DRB Application No.: 05DRB-01631 (SBP)

Project Name: THE SPORTS COURT

**City Of Albuquerque
PLANNING DEPARTMENT
October 26, 2005
DRB Comments**

RE: The Sports Court/SPB

DATE: 10.13.2005 sheet-  
 SCALE: 1"=30' L1.0  
 of.

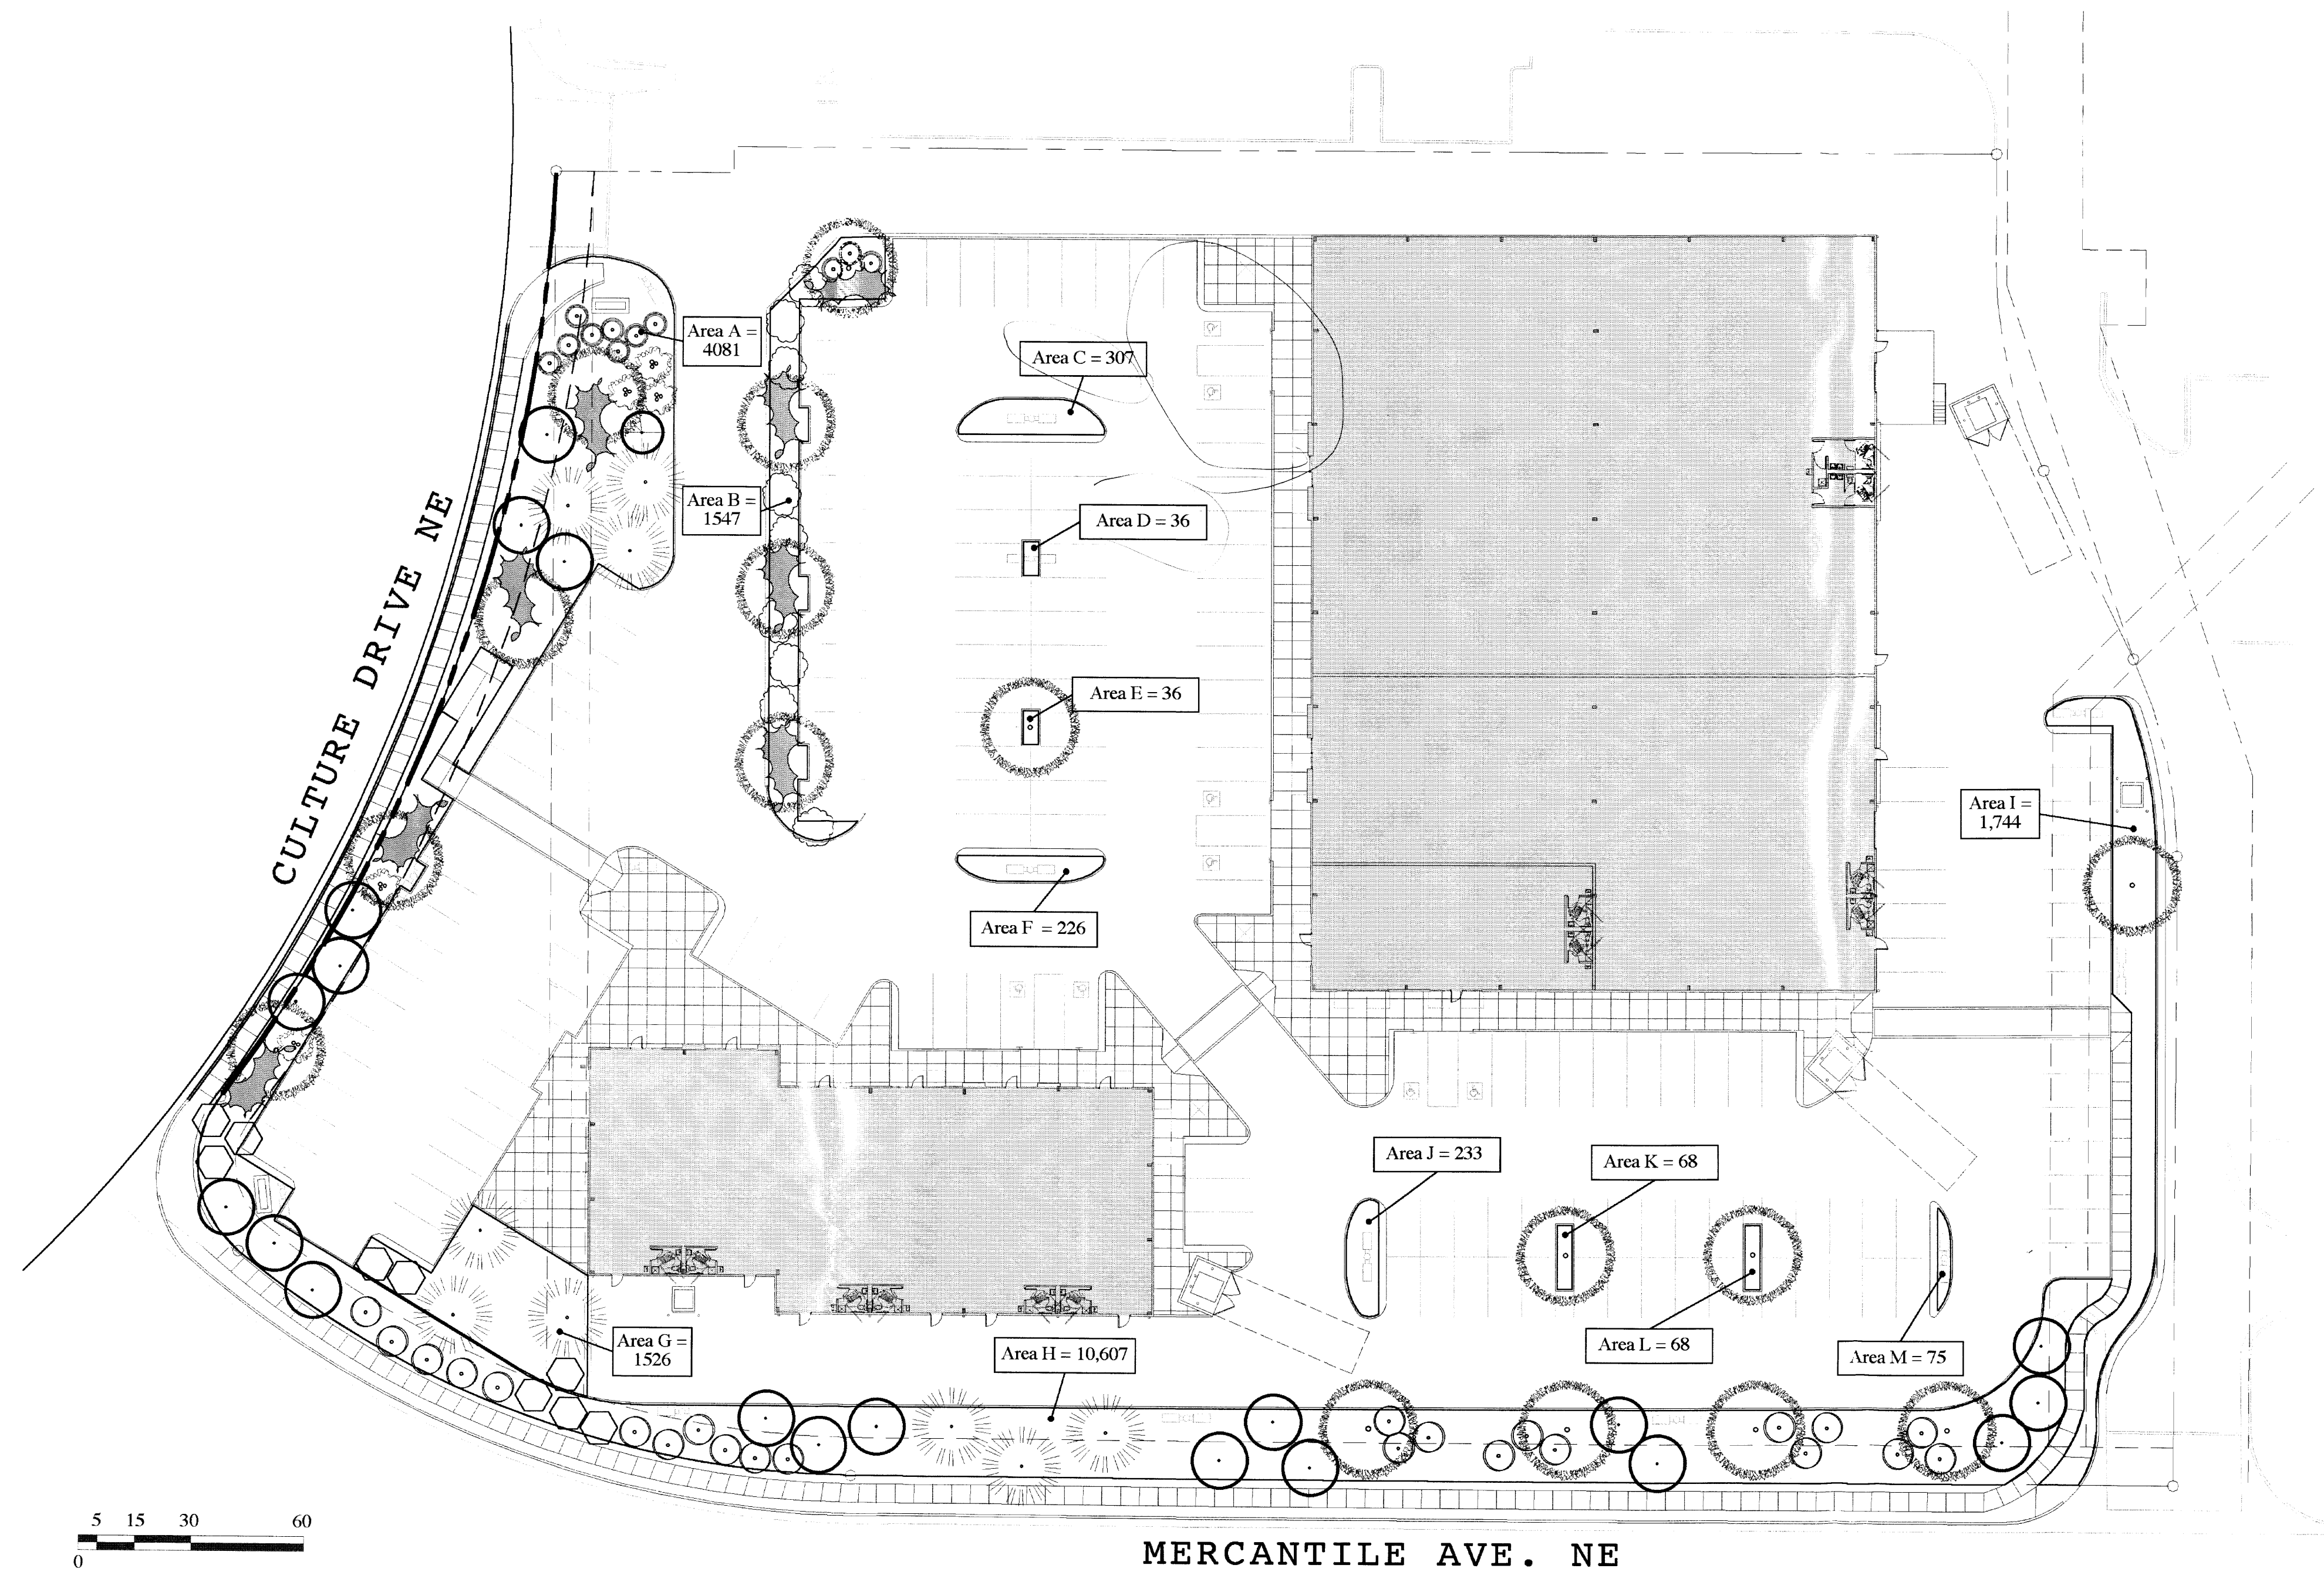
The irrigation system maintenance agreement is missing on the Landscape Plan (property owner or other).

Clearly indicate the property boundaries on the Landscape Plan.

Show all easements on the Landscape Plan.

Indicate the number of plants on the Landscape Plan, and show the locations of all plants.

The title block on the Landscape Plan is incorrectly labeled Site Development Plan for Building Permit.

| DATE:<br>10.18.2005   | sheet:<br><b>A7</b> |

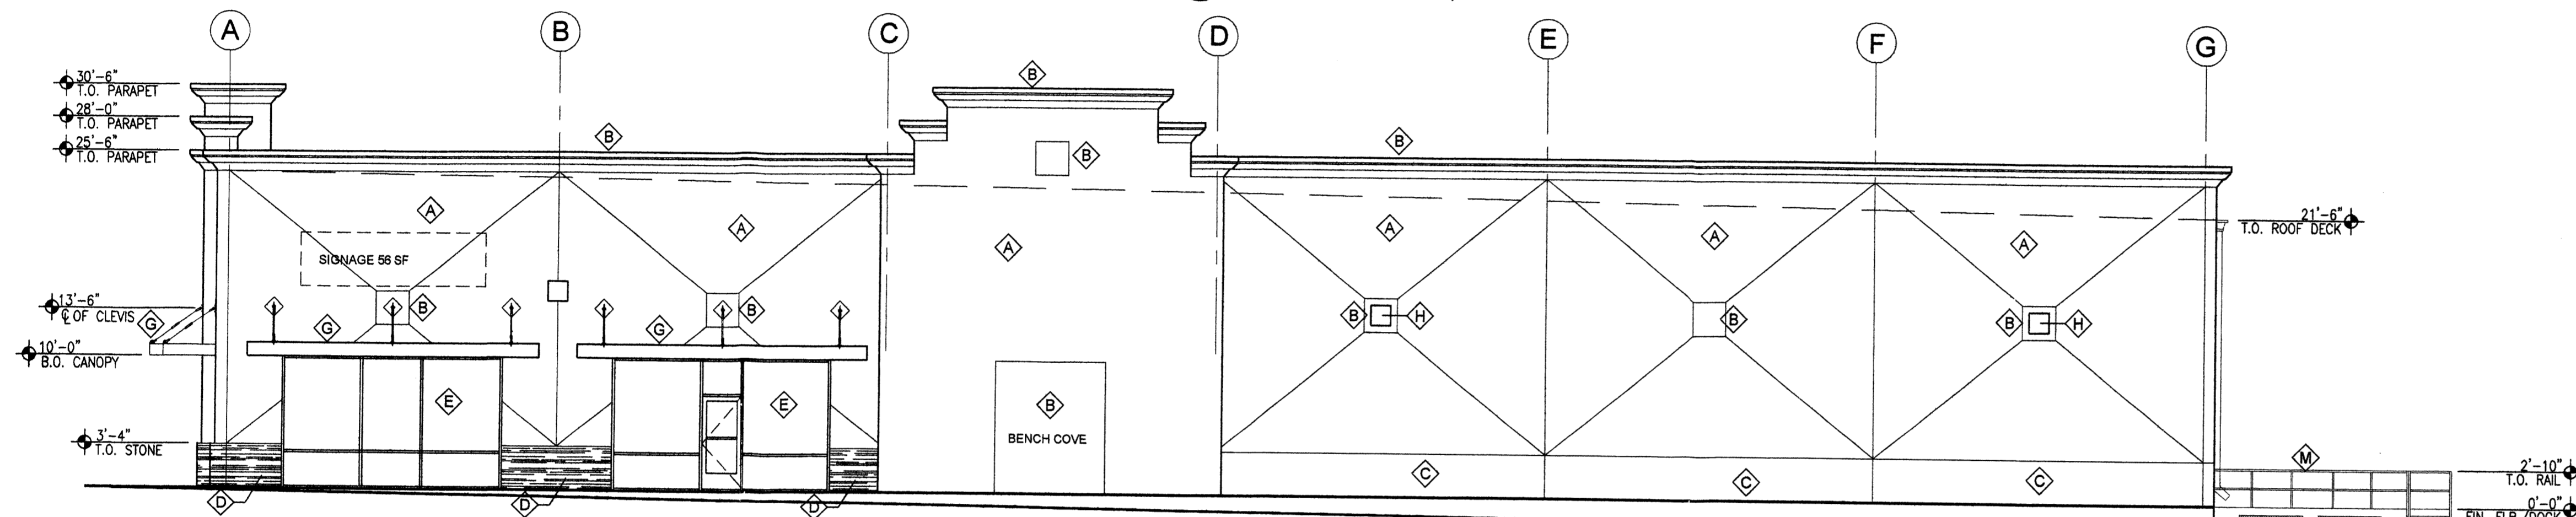
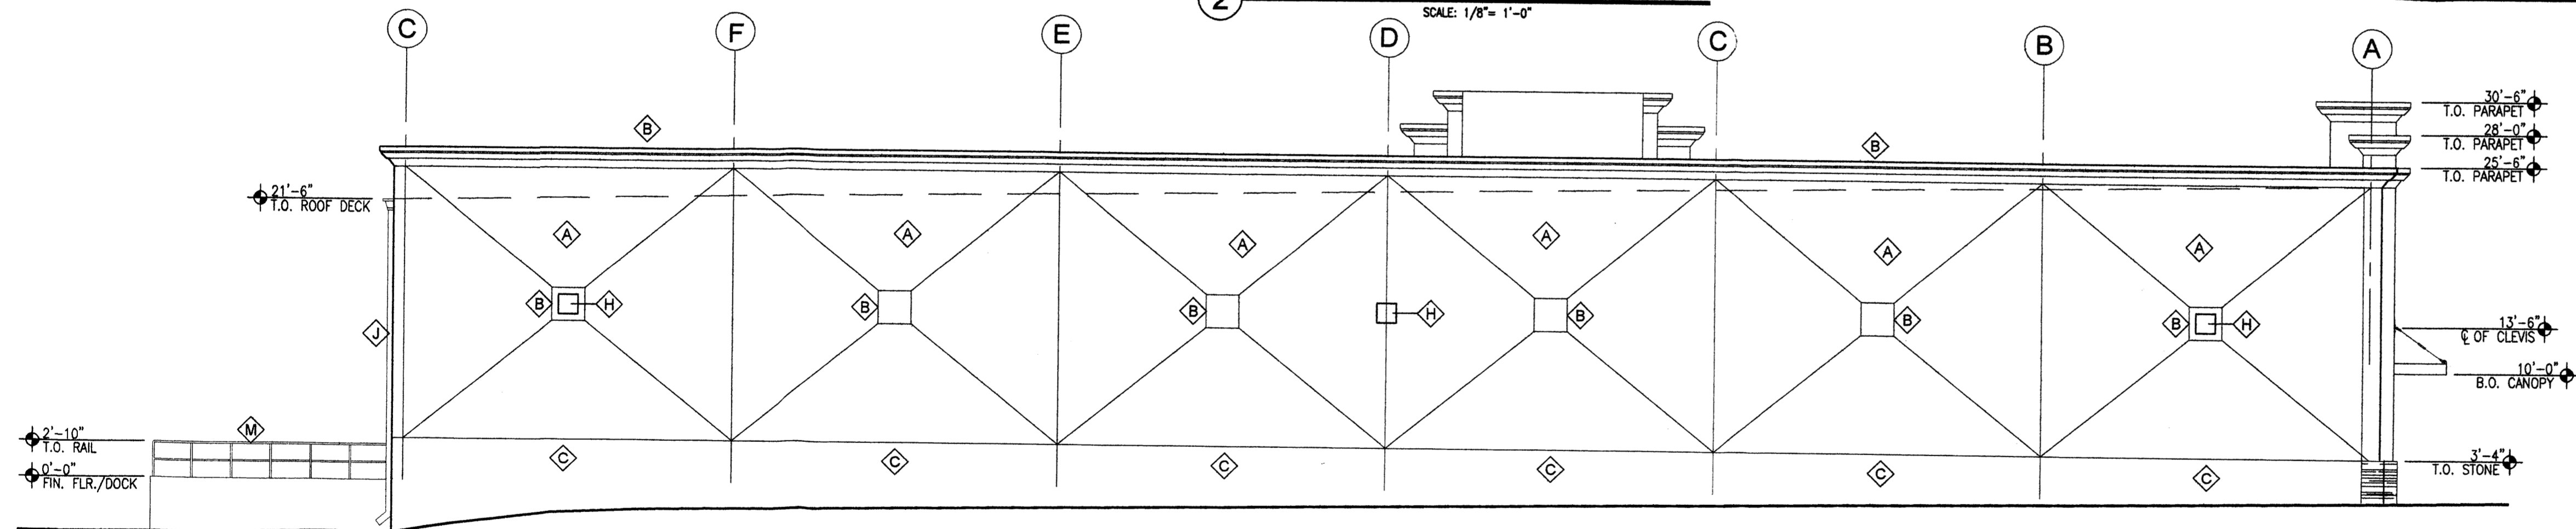
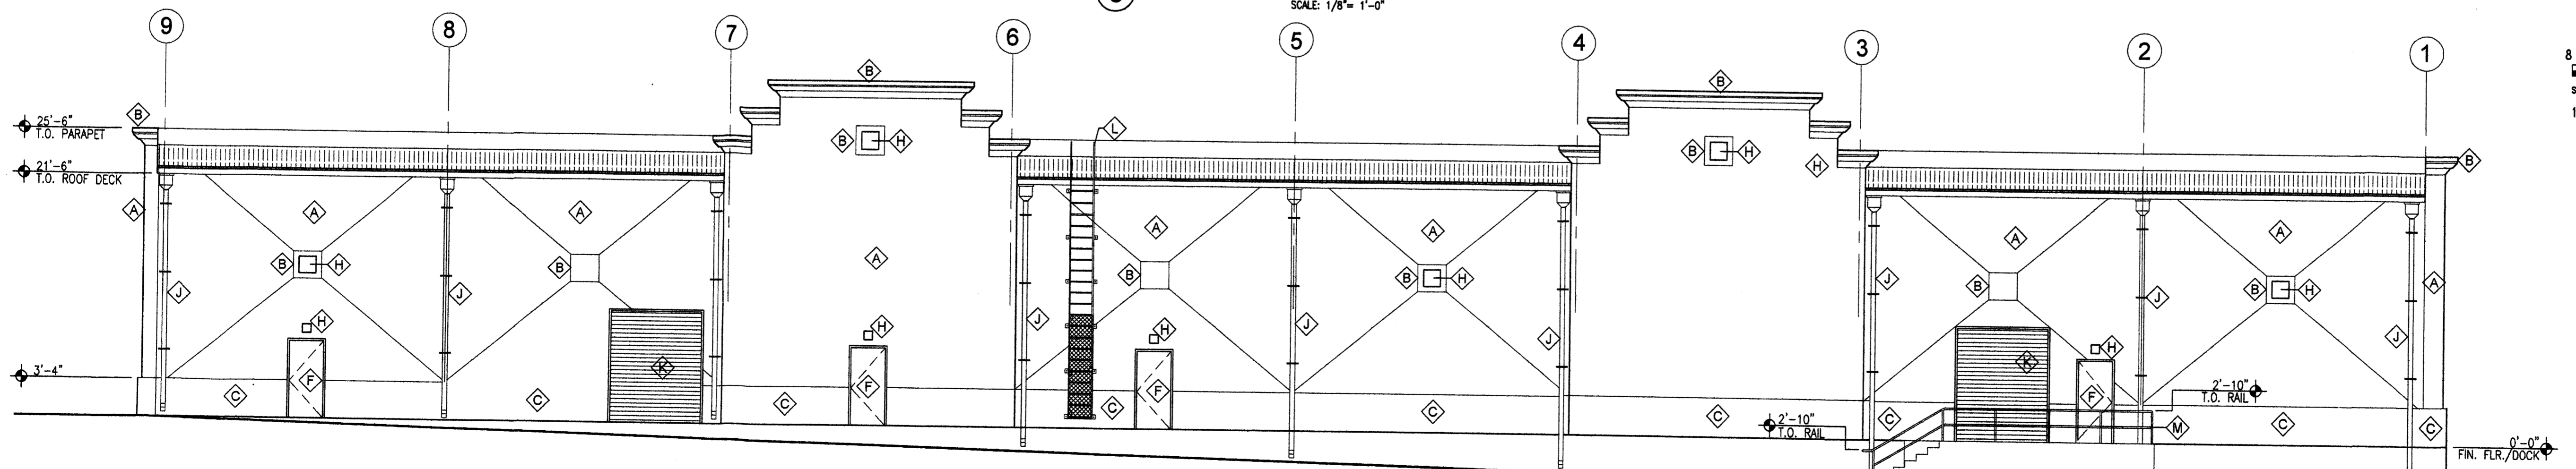
There are two elevation drawings, one for JA1/JA2 (A7) and one for Shops elevation (A7.1). Clarify what elevation buildings they correspond to.
